DRB CASE ACTION LOG

DRB Application No.: 03-01044 (SBP)	Project # 1002060
Project Name: NETHERWOOD PARK ADD.	EPC Application No.: Z-93-81
Agent: Jack M Harris, Architects	Phone No.: 266-6667

10. **Project # 1002060**
03DRB-01044 Minor-SiteDev Plan
BldPermit/EPC

DRB-1002060

UTILITY PLAN

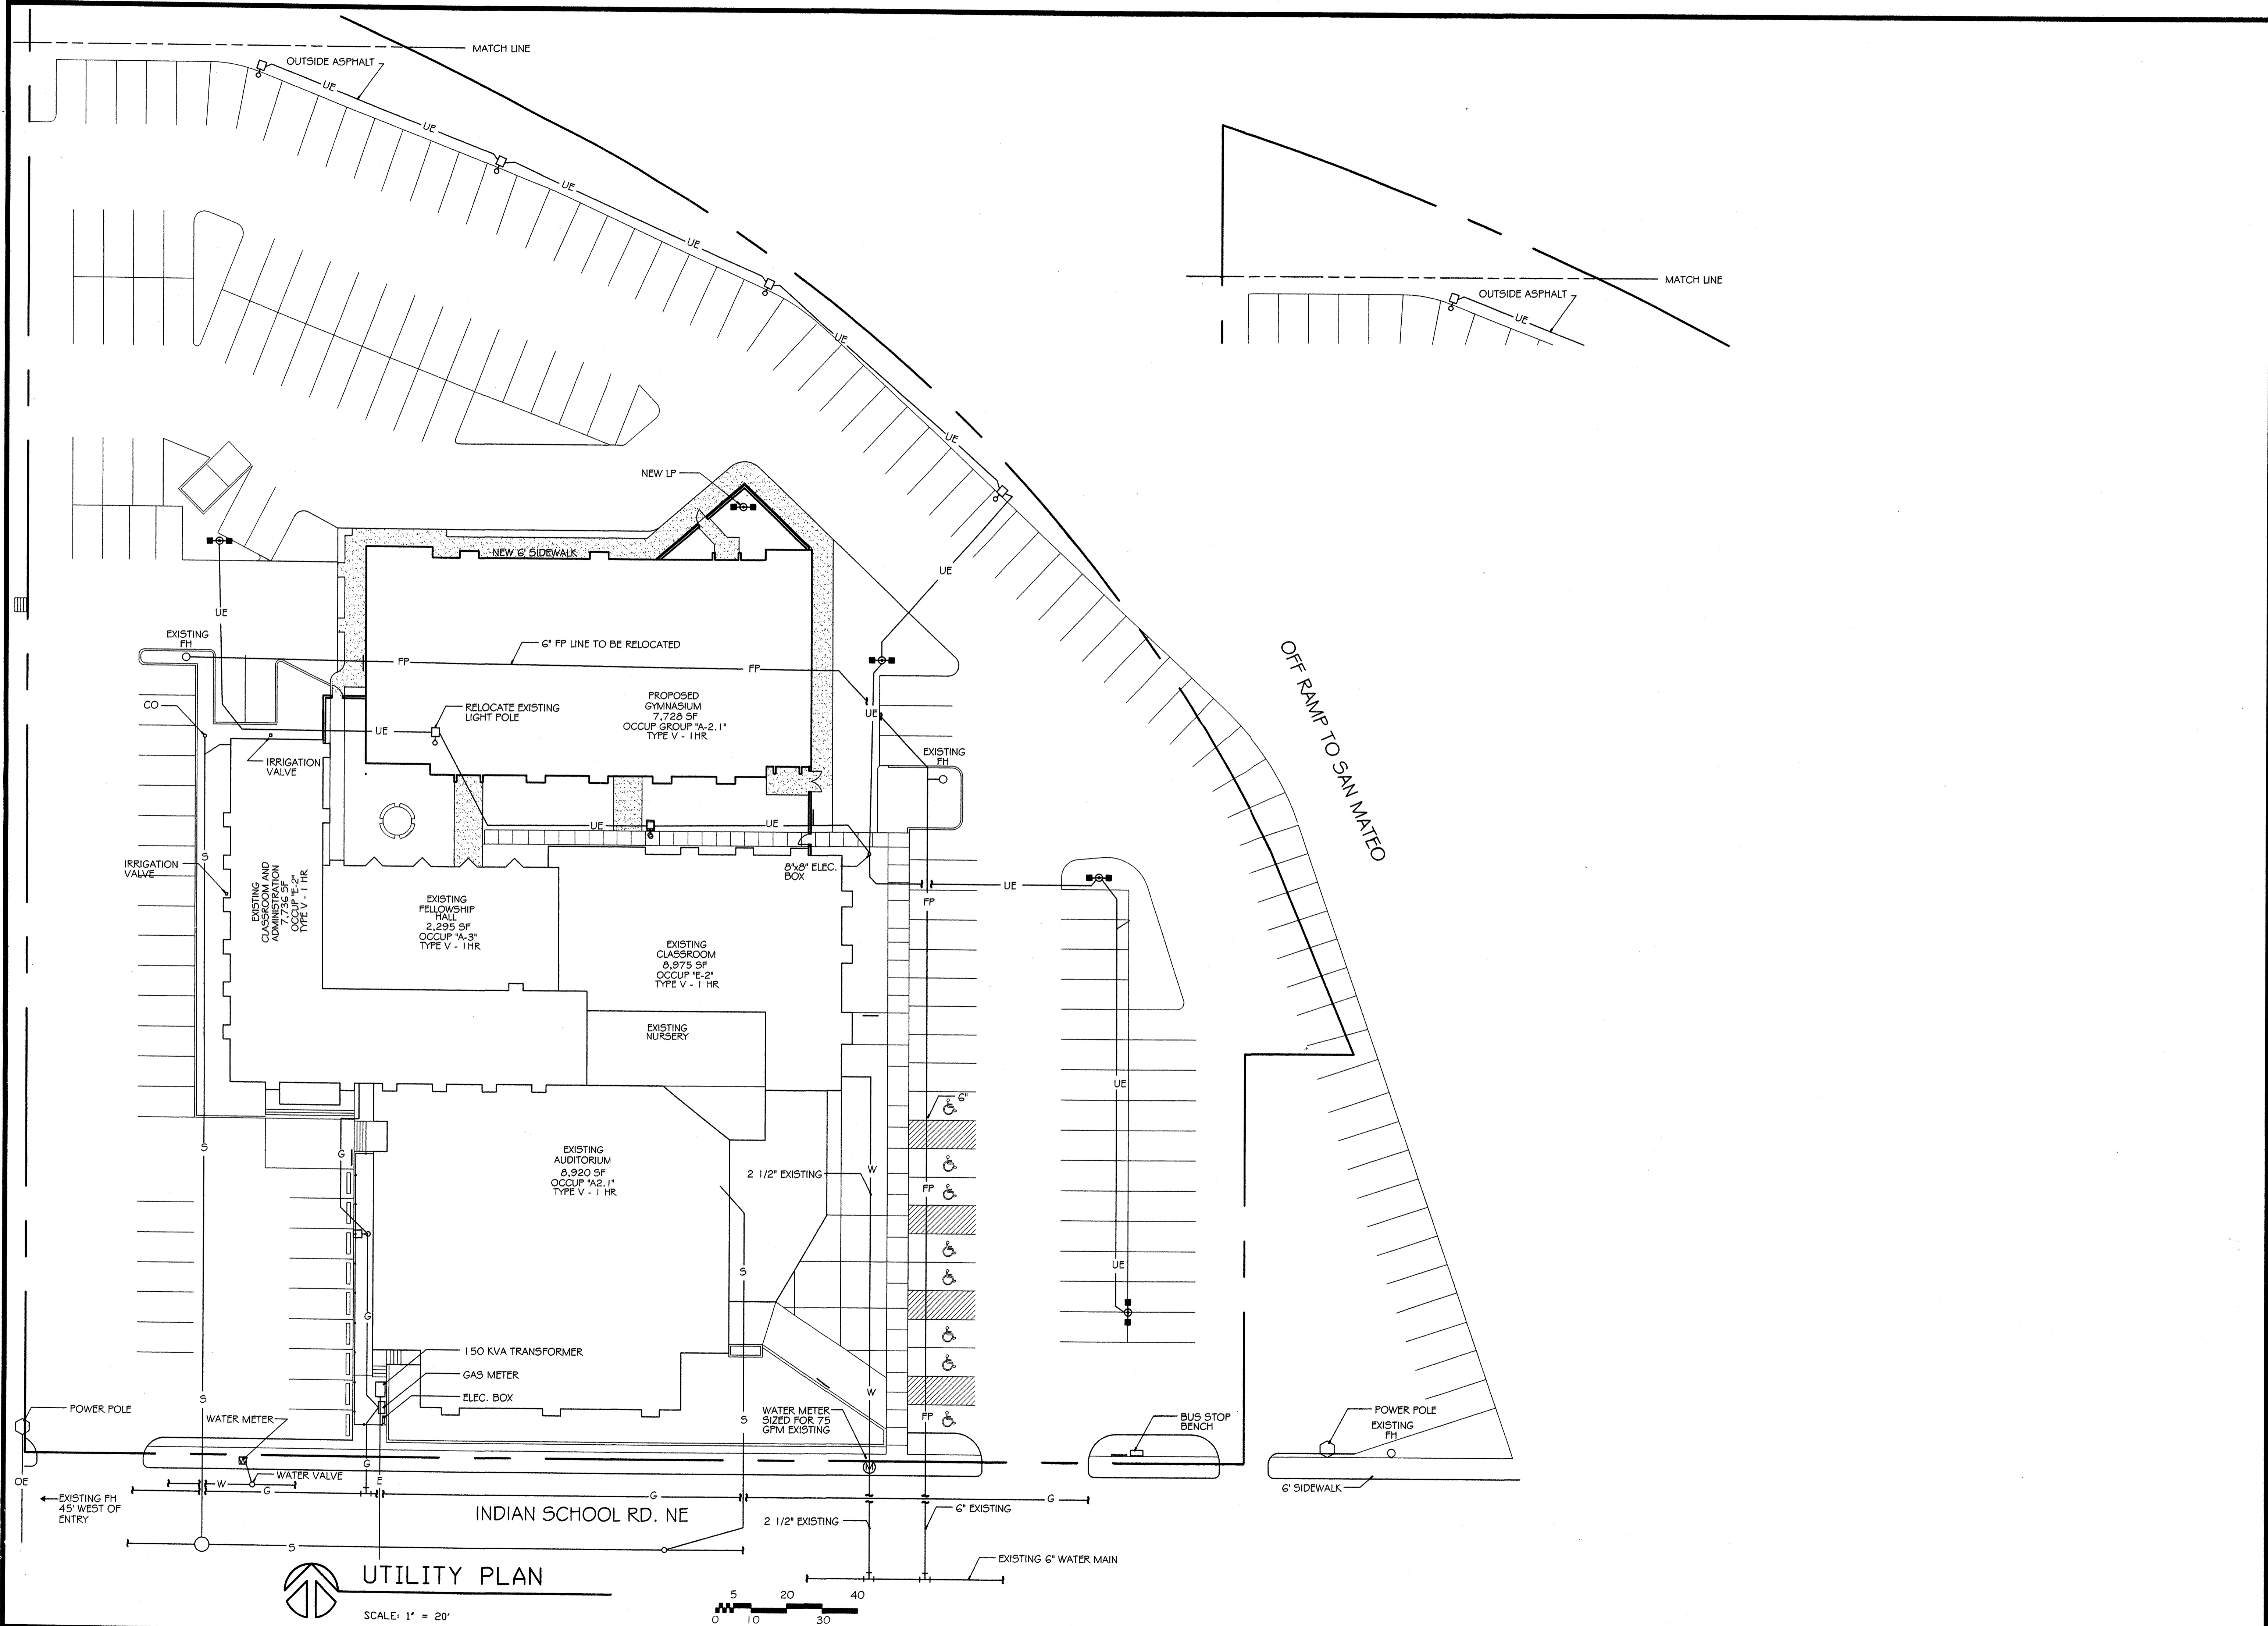
Need updated fire Marshal calcs

Utility Plan as shown will NOT provide fire protection

JACK M. HARRIS, ARCHITECTS INC., agent(s) for NETHERWOOD PARK CHURCH OF CHRIST request(s) the above action(s) for all or a portion of Tract(s) F-1, **NETHERWOOD PARK ADDITION**, zoned SU-1 Church/Related Facilities, located on INDIAN SCHOOL RD NE, between SAN MATEO NE and WASHINGTON NE containing approximately 3 acre(s). [REF: Z-75-84, Z-68-59, Z-68-94, Z-93-81] [RUSSELL BRITO, EPC CASE PLANNER] (H-17) **THE SITE PLAN FOR BUILDING PERMIT WAS APPROVED WITH FINAL SIGN OFF DELEGATED TO UTILITIES DEVELOPMENT FOR UPDATED FIRE CALCS AND THE WAY THE UTILITY PLAN IS SHOWN IT WILL NOT PROVIDE FIRE PROTECTION.**
